Tuesday, 15 January 2019

Re: Planning Application reference R/306/18/PL

TITLE
PROPOSED DWELLING
FIRST FLOOR PLAN

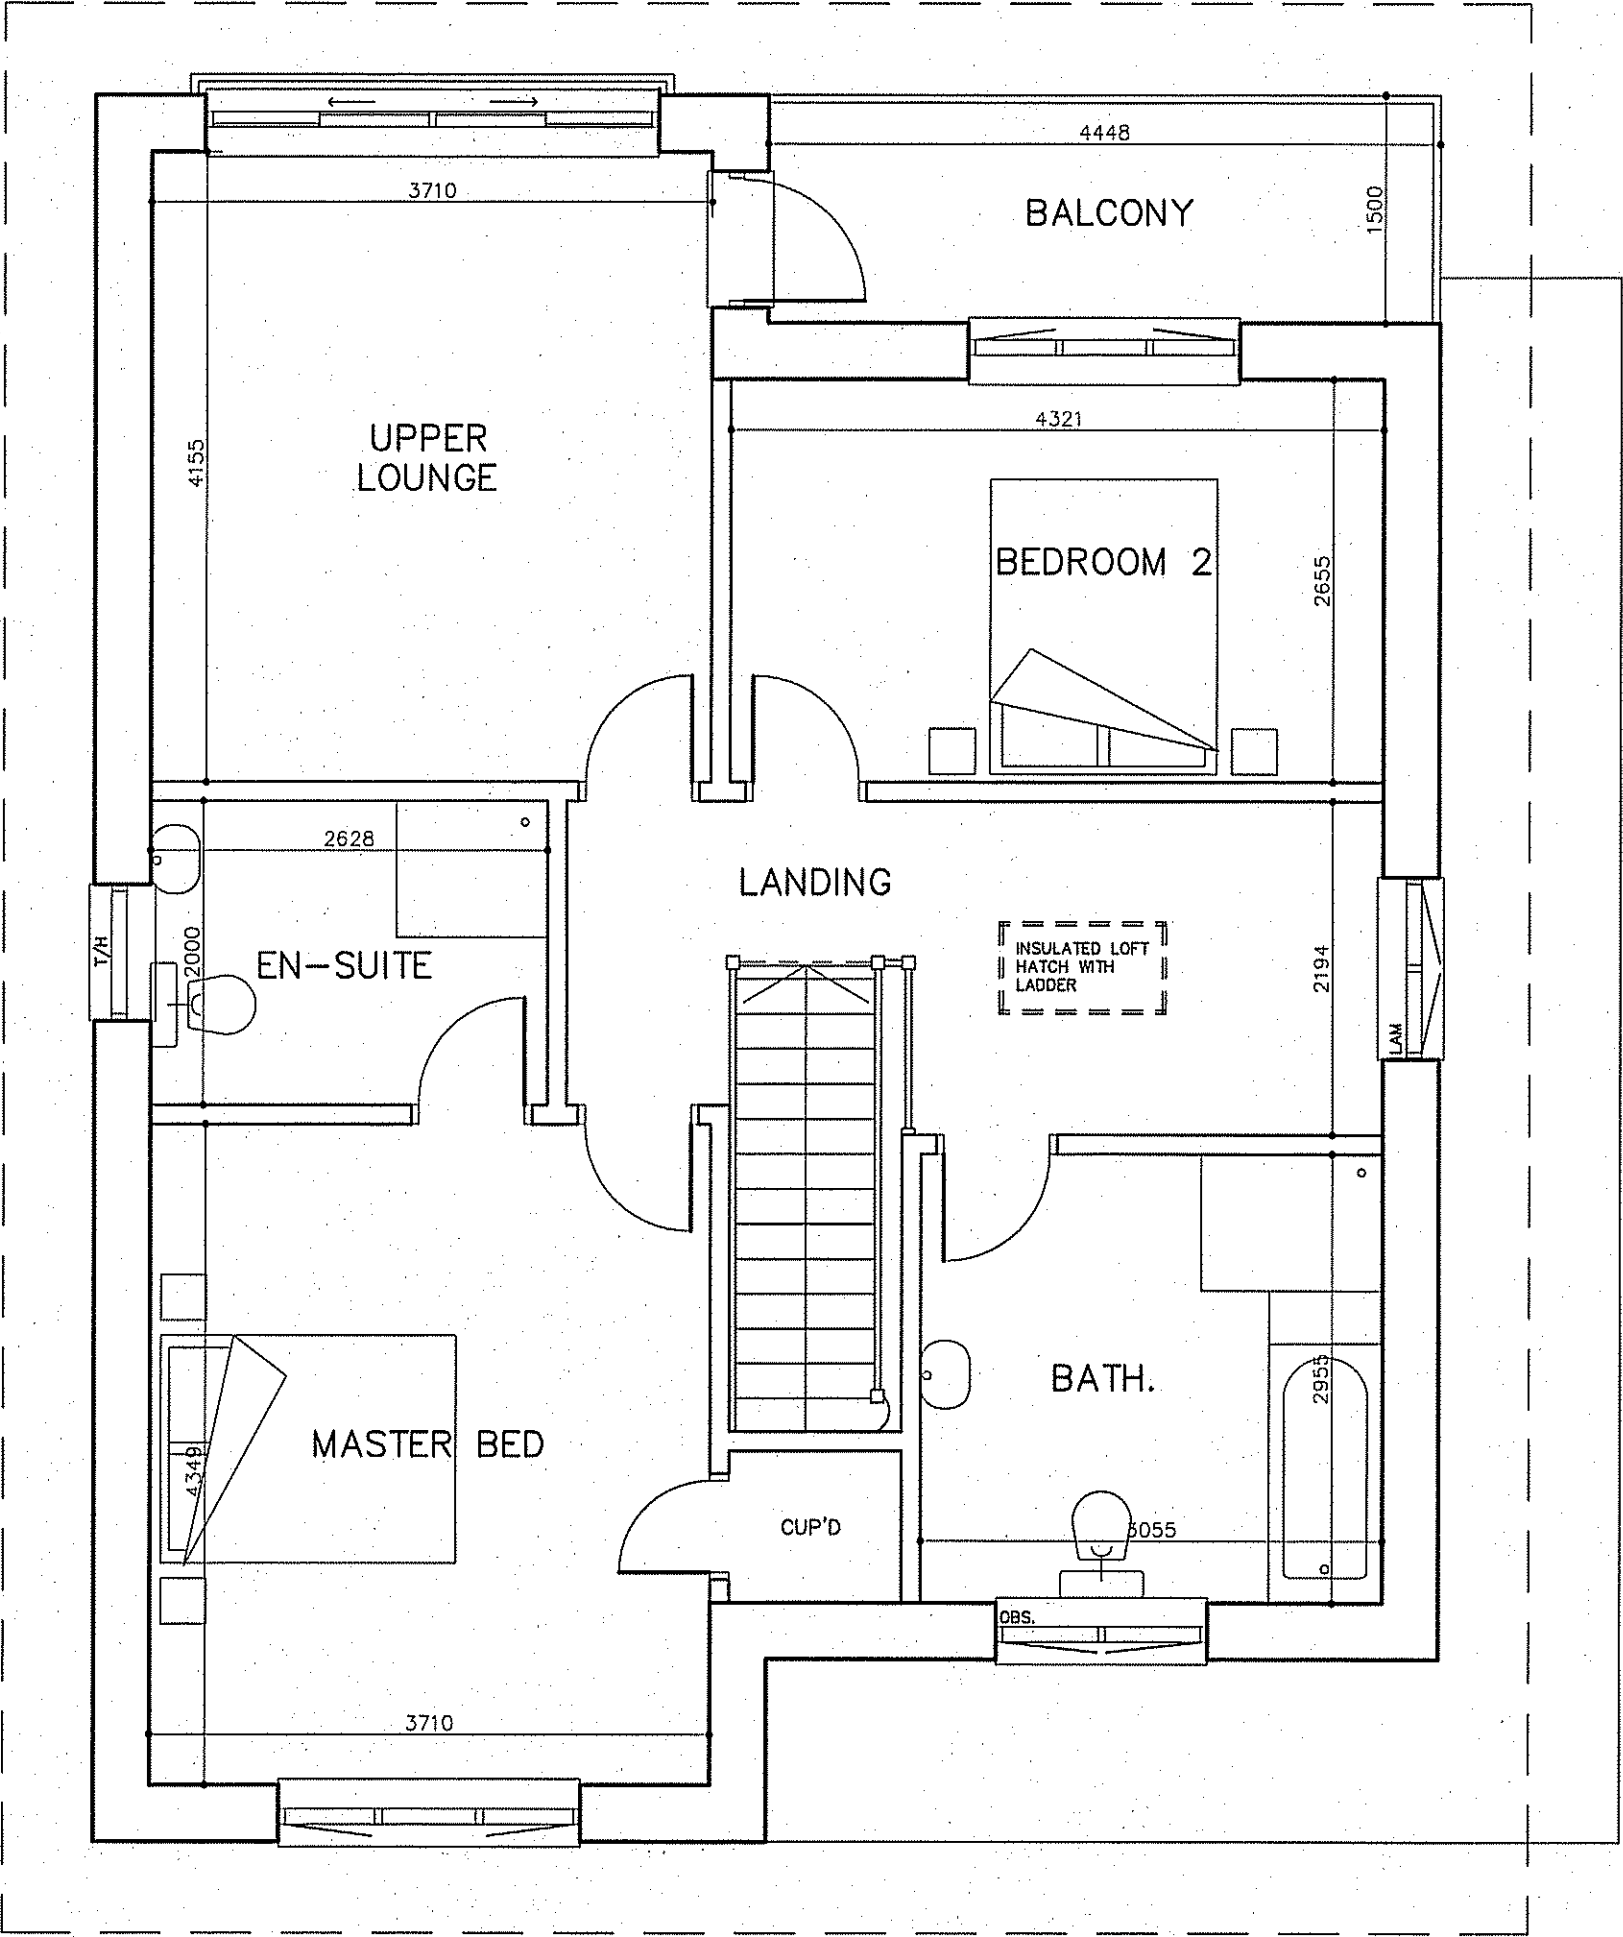
Our concern, as immediate neighbours to the East of the proposed development, is connected with the balcony on the first floor, and possible invasion of privacy. The plans appear to be contradictory. The drawings on the 'Design and Access Statement' indicate that the balcony is on the East side of the build extending out from the 'Upper Lounge'. However, on the drawing 'Proposed Dwelling First Floor Plan dwg.03' the balcony is illustrated as being on the West side of the build, off 'Bedroom 2'. There would be no possibility of privacy invasion if the balcony is on the West side and within the building line but we would like to object if the intention is to build out from the East side. Such an extension would be intrusive, giving direct views into our garden and living room.

SCANDIA-HUS BUSINESS PARK, FELCOURT ROAD, FELCOURT, EAST GRINSTEAD, WEST SUSSEX, RH19 2LP : TEL 01342 838060		
FOR MR & MRS MOOR		
SITE WINDSONG, THE THATCHWAY, RUSTINGTON, BN16 2BN		
TITLE PROPOSED SITE PLAN		
C/No. 222858	O/No.	SCALE 1/200 @ A2
DRAWN FC		DRAWING NUMBER SP02
DATE 06/18		
		REV

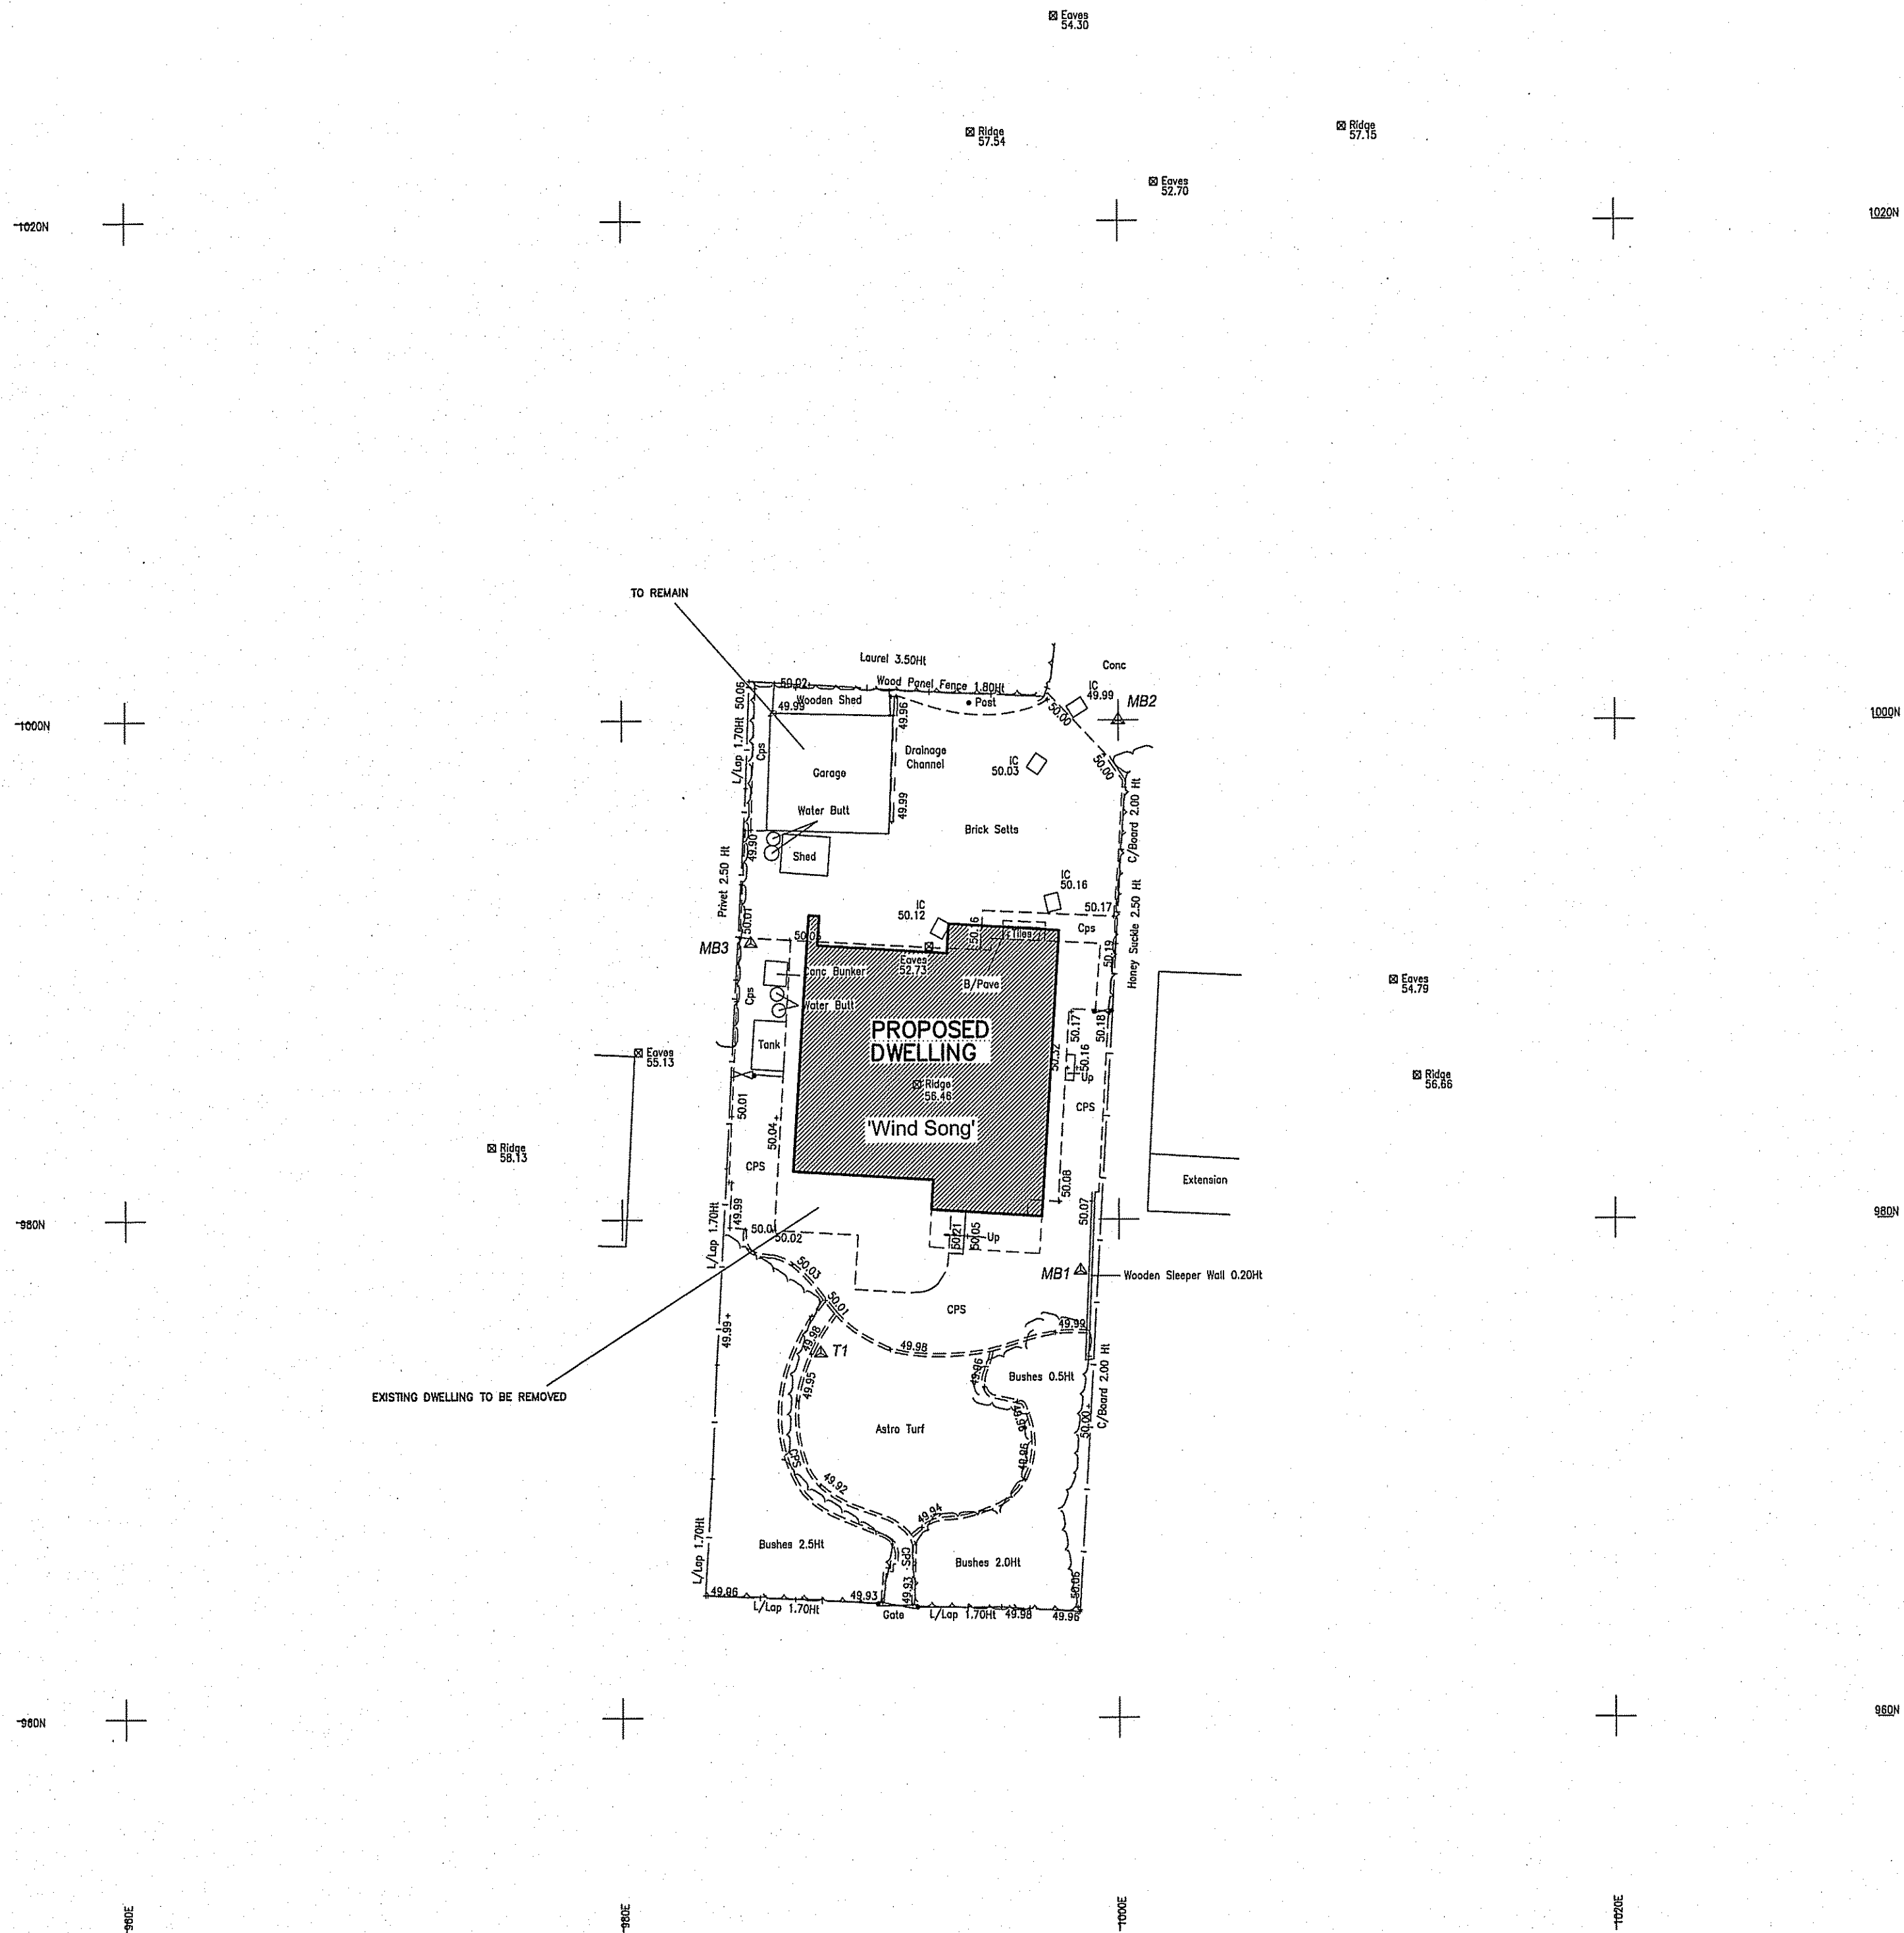
Could you please explain how the access is going to be 'improved' bearing in mind the narrow access runs between two private properties, bordered by fencing?
